Historic England

17 May 2016

LAND ADJACENT OLD BANK MILL, HOWGATE ROAD, SLAITHWAITE, HUDDERSFIELD, HD7 5AR

Application No 2016/62/90494/W

PROPOSED RESIDENTIAL DEVELOPMENT AT OLD BANK, SLAITHWAITE			
CLIENT S.B. HOMES LTD			
WILLIAM BEST RISA THE CHAPEL HOUSE 22, FOLE GATE SCAMMONDEN WEST YORKSHIRE HD3 3PW 01484 845896			
DRAWING: PROPOSED SITE PLAN			
SCALE:	B4	DATE	
1:200	WB	14/01/2016	
2015/319	100

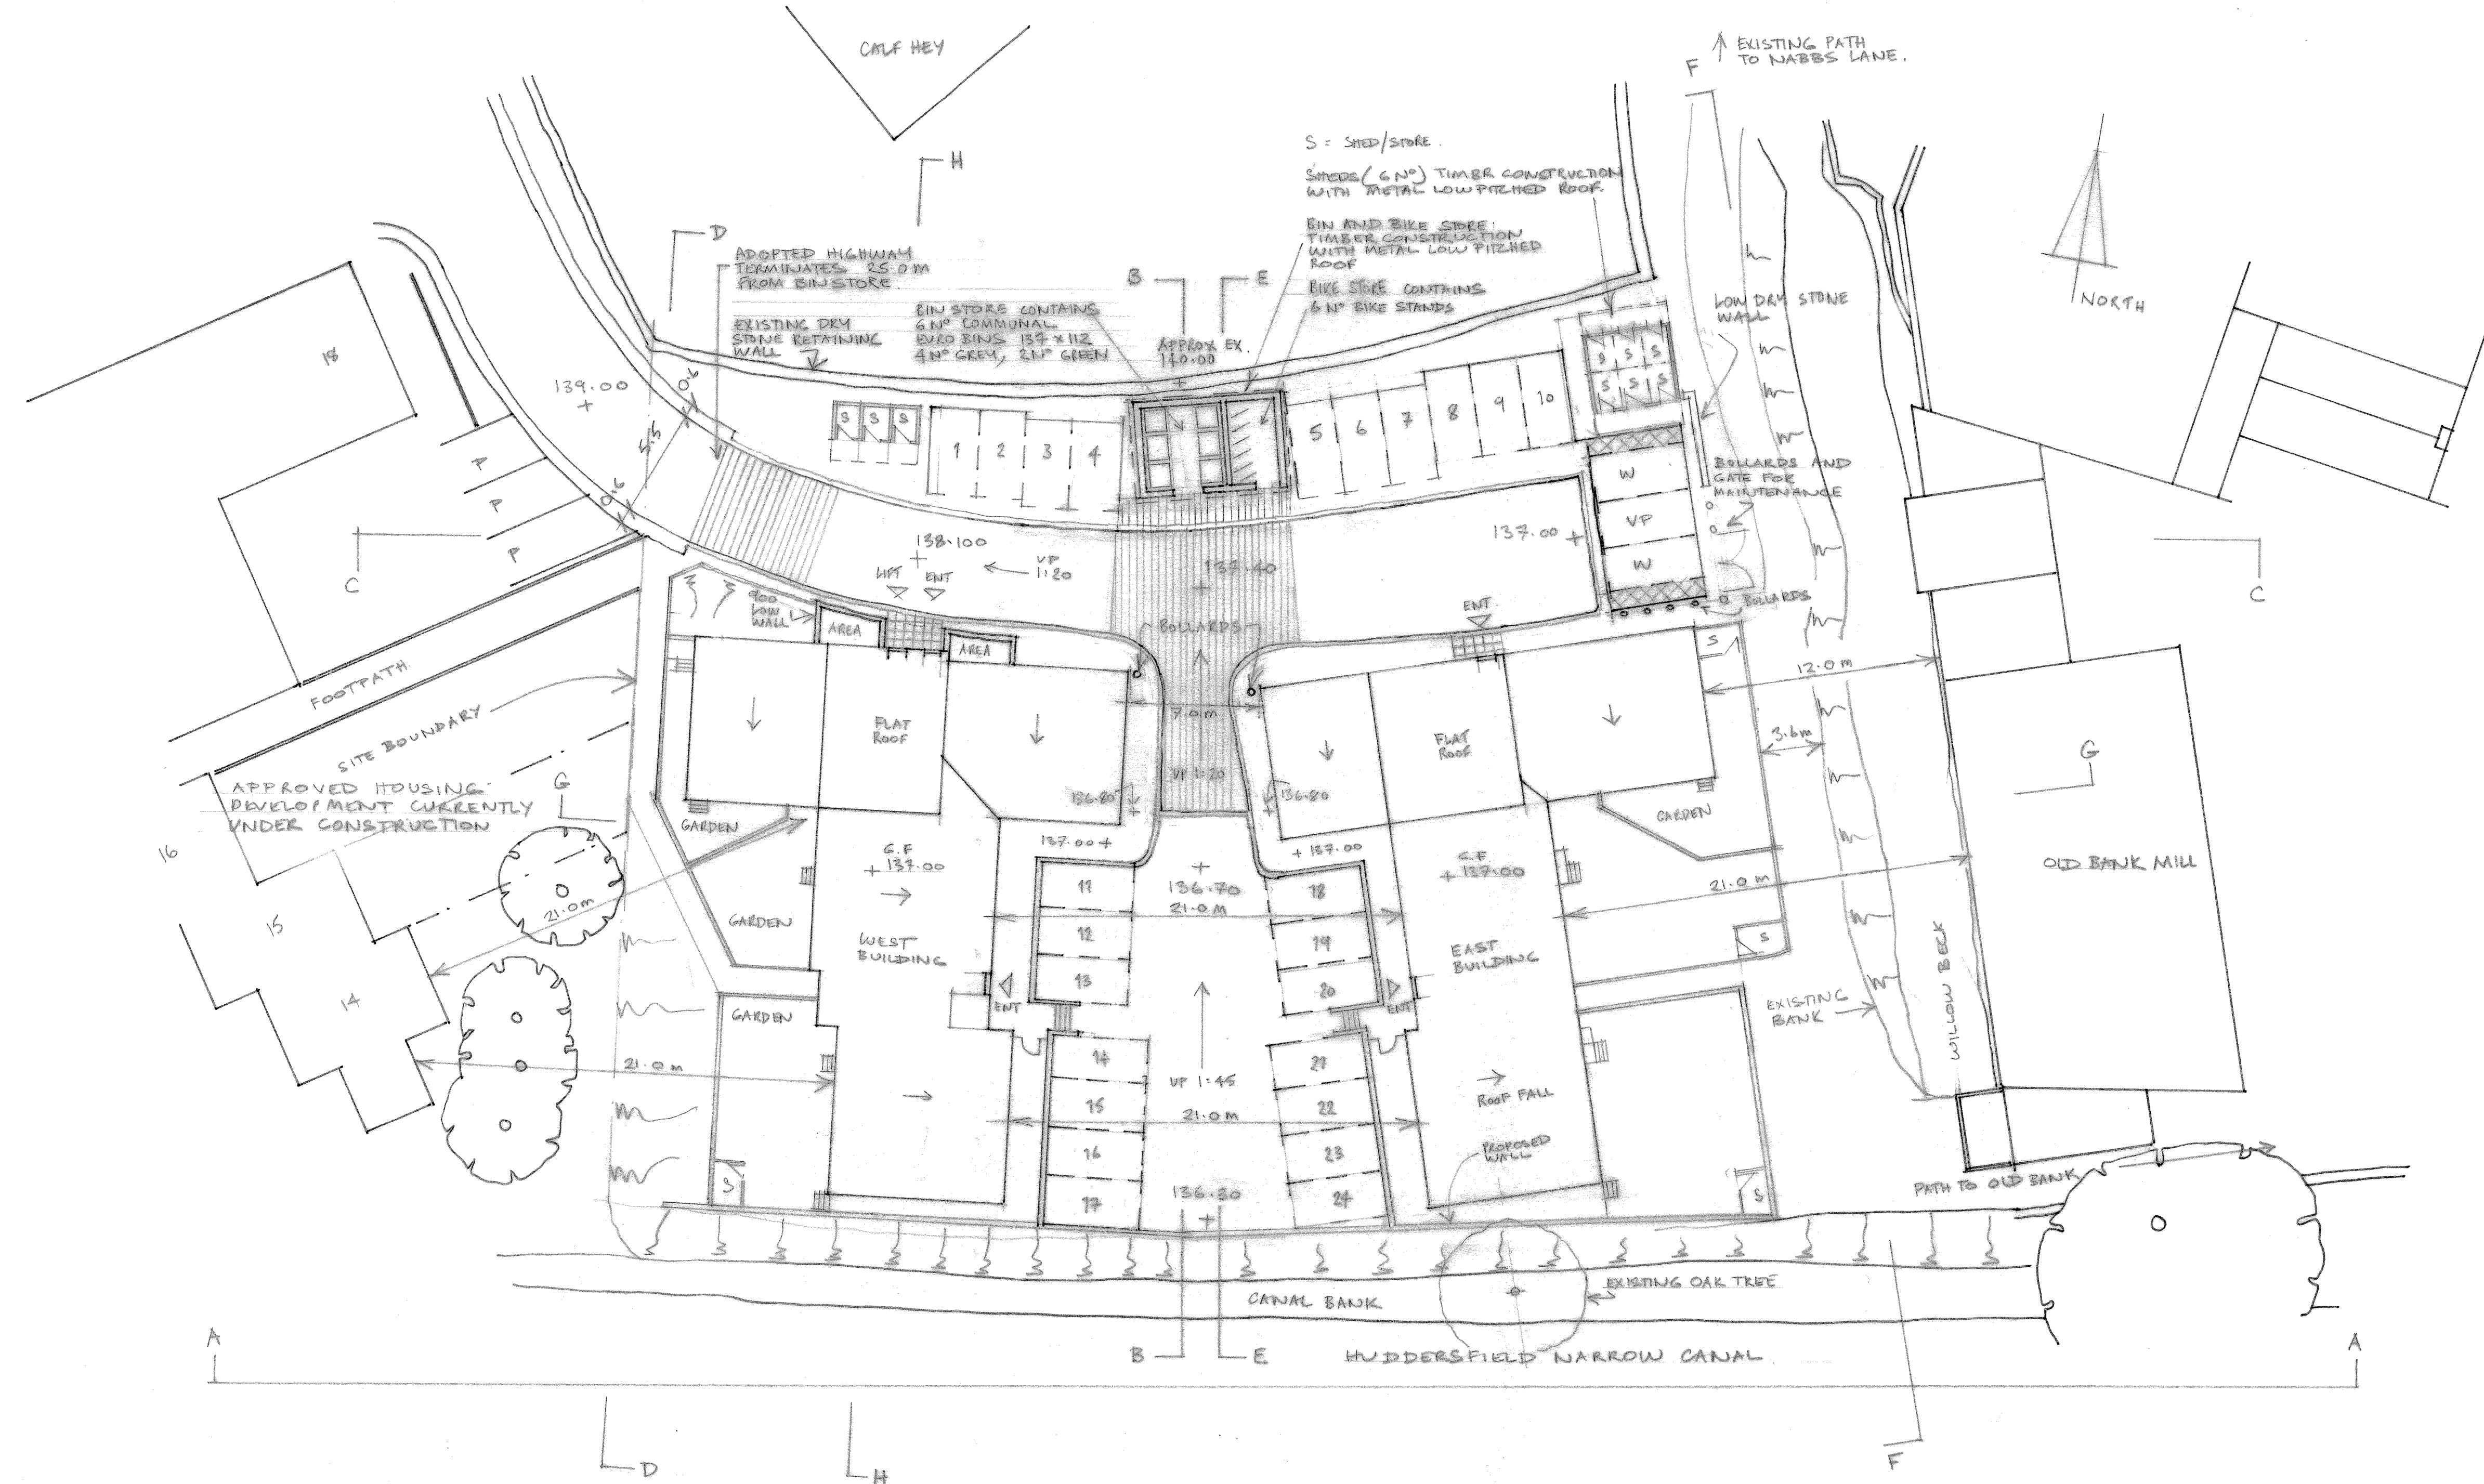
Historic England supports the principle of some housing in this location. Nevertheless we are concerned that the siting, massing and height of the proposed blocks will restrict views across the site towards the Manor House and the wider Conservation

Area. In order to fully understand the impact of the new development upon the setting of the Grade II* listed Manor House and adjacent designated heritage assets, we advise that a number of street scene views or CGIs are undertaken from key points along the Canal and across the site indicating the proposed development.

We also request that a more detailed public realm and landscaping scheme is submitted. We consider there is an opportunity to strengthen existing soft landscaping as well as introduce traditional paving and boundary treatments such as low dry stone walls. We advise that these amendments are sought to the design in order that the development will visually link to and complement adjacent heritage assets as well as screen the prominent areas of car parking proposed.

PROPOSED RESIDENTIAL DEVELOPMENT AT OLD BANK, SLATTHWAITE			
CLIENT S.B. HOMES LTD			
DRAWING: PROPOSED SECTIONS			
WILLIAM BEST RIBA	SCALE: 1:100	BY WS	DATE 14/01/2016
THE CHAPEL HOUSE			
22, POLE GATE			
SCAMMOLDEN			
WEST YORKSHIRE HD3 3PW			
01484 845896			
			2015/319/103

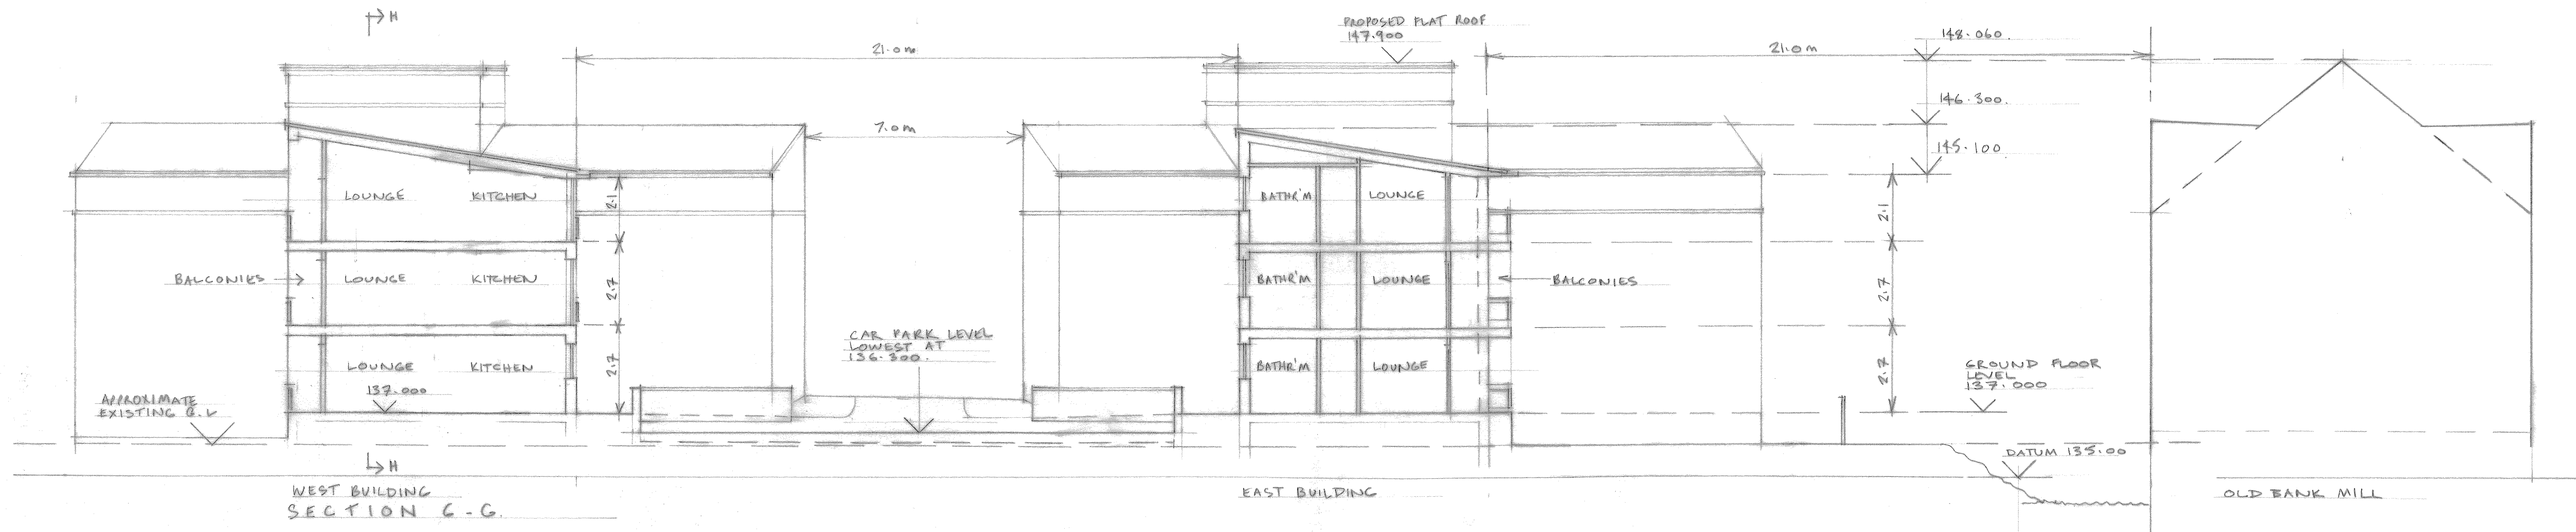
In addition we request that further consideration be given to the proposed architectural treatment, palette of materials and soft landscaping in order to assist in mitigating the harm of the proposed development. Whilst we note that the use of dark grey metal cladding and profiled metal roofing has been agreed at the adjacent Old Bank Mill, we are concerned regarding the prolific use of these materials in conjunction with the proposed development. We request that an alternative traditional palette of materials is sought to enhance the setting of the adjacent heritage assets.
